Recommendation Report for Planning Permission for Works or Extension to a Dwelling

REF NO: BR/114/22/HH

LOCATION: 5 Highland Avenue
Bognor Regis
PO21 2BJ

PROPOSAL: Erection of single storey rear extension following the demolition of existing rear lean-to.

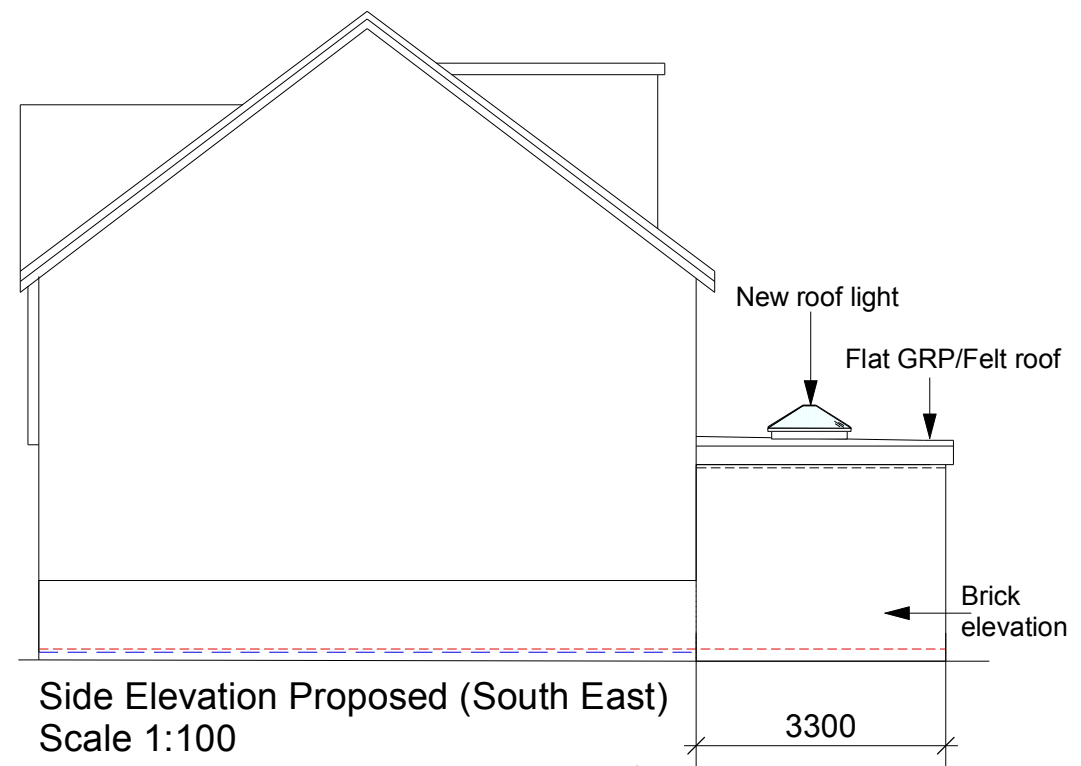
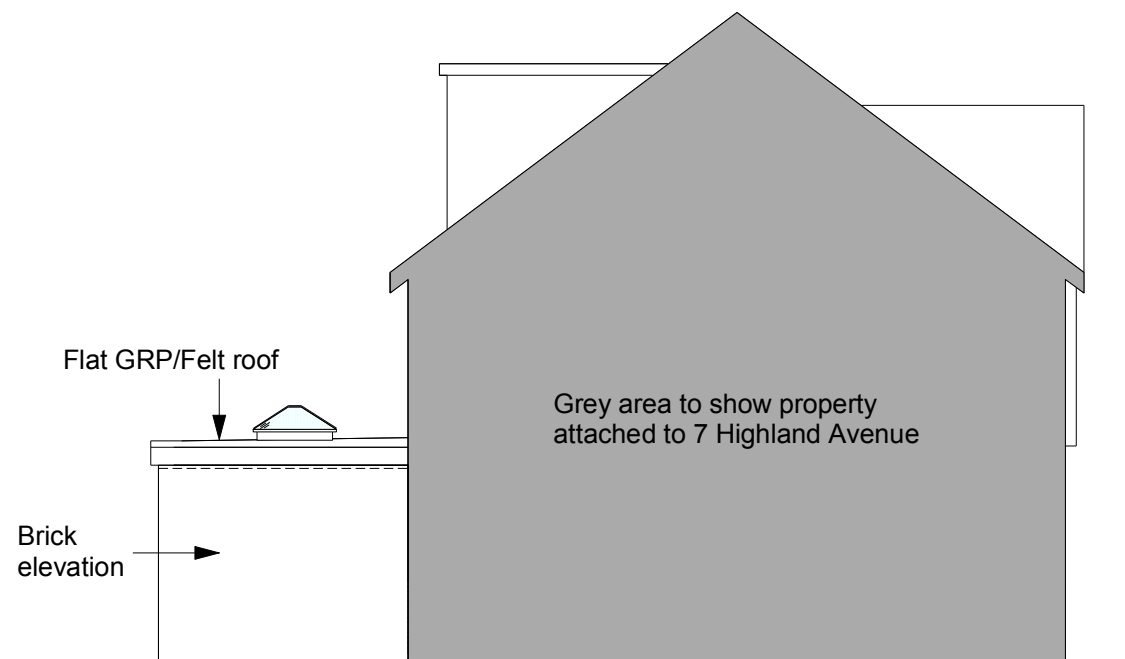
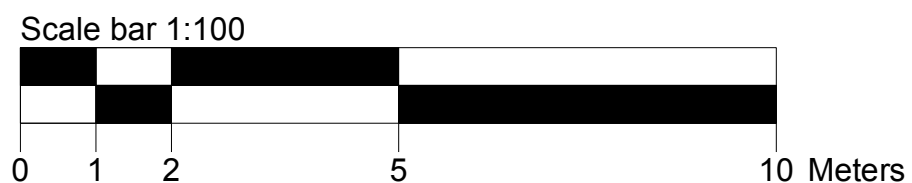
The extension will replace a glass lean to. It is an appropriate replacement, retaining a modest scale of 3.3m in depth and 5.86m in width. It will have a flat roof which, although differing to the gable roof of the main dwelling, will follow a similar style to the existing flat roof dormer. This will not appear unduly out of place with the host dwelling and will integrate well with the existing. The extension will have minimal impact on the visual appearance of the property and will be in keeping with its established character. Being to the rear, it will not be visible from the street scene and will have no impact on the composition or appearance of the street. It remains in keeping with the character of the area and will have insignificant impact on visual amenity.

In addition to the roof light, the proposal will feature two sets of windows and a single door to the northeast (rear) elevation. These features will face the rear garden and will not unduly overlook any neighbouring properties. They pose no risk of harm to residential privacy or amenity and are acceptable.

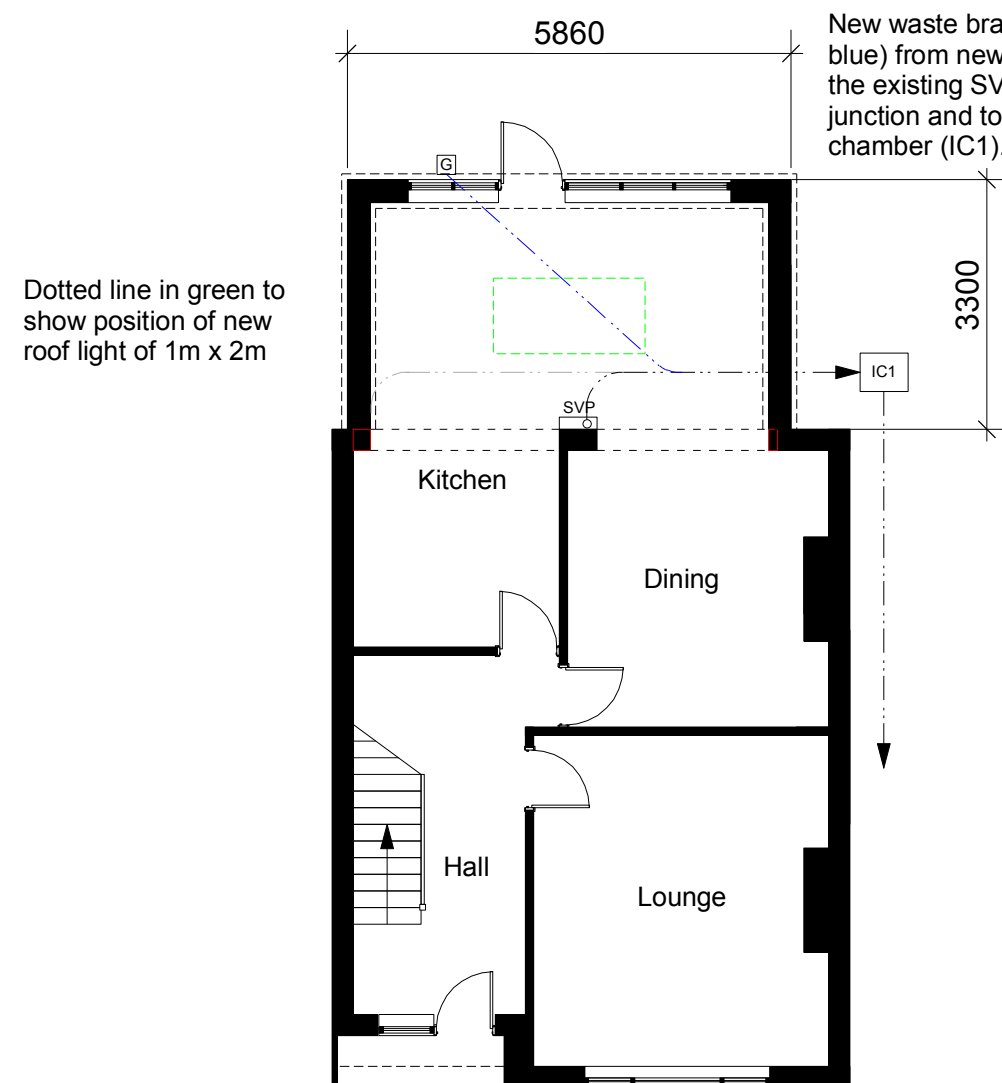
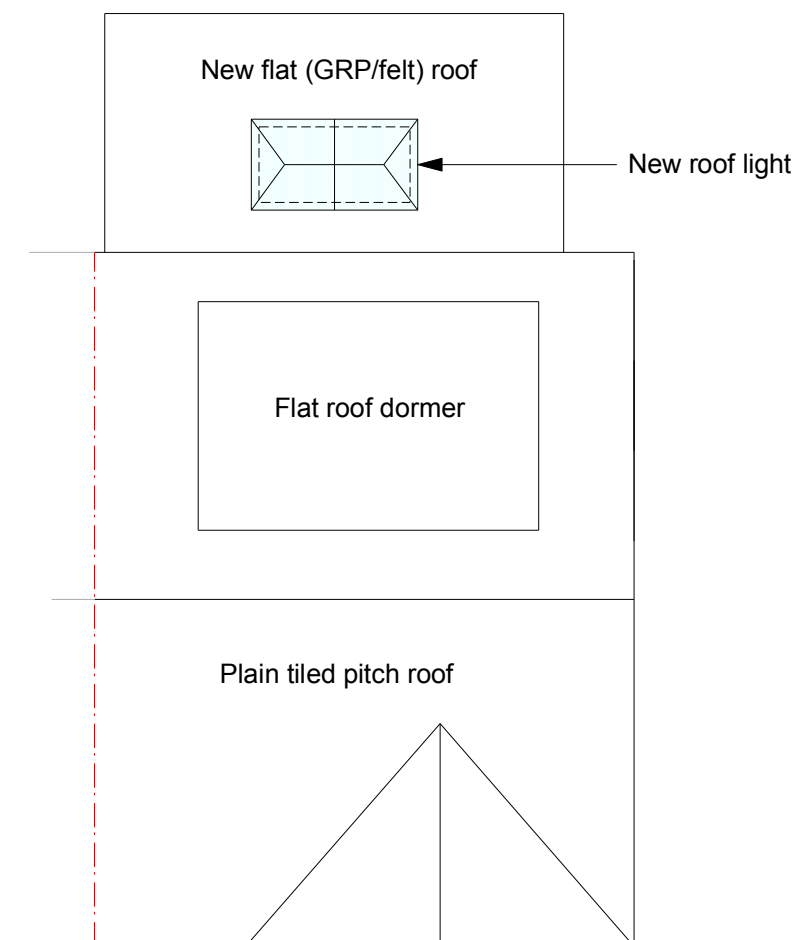
The proposed will be single storey and have a flat roof at a height of 3m. This roof will include a roof light which will protrude slightly above but will have no harm on residential amenity. The proposal itself will retain 0.21m to the northwest boundary, 24m to the northeast, and 1.72m to the southeast. Being single storey, this is in accord with D DM4 of the Arun Local Plan. The extension will not protrude past the rear elevation of No.7 to the northwest and does not conflict the 45 and 60 degree rules when taken from either neighbouring property to the sides. As such, it will not result in any adverse overbearing or overshadowing and will have minimal impact on residential amenity.
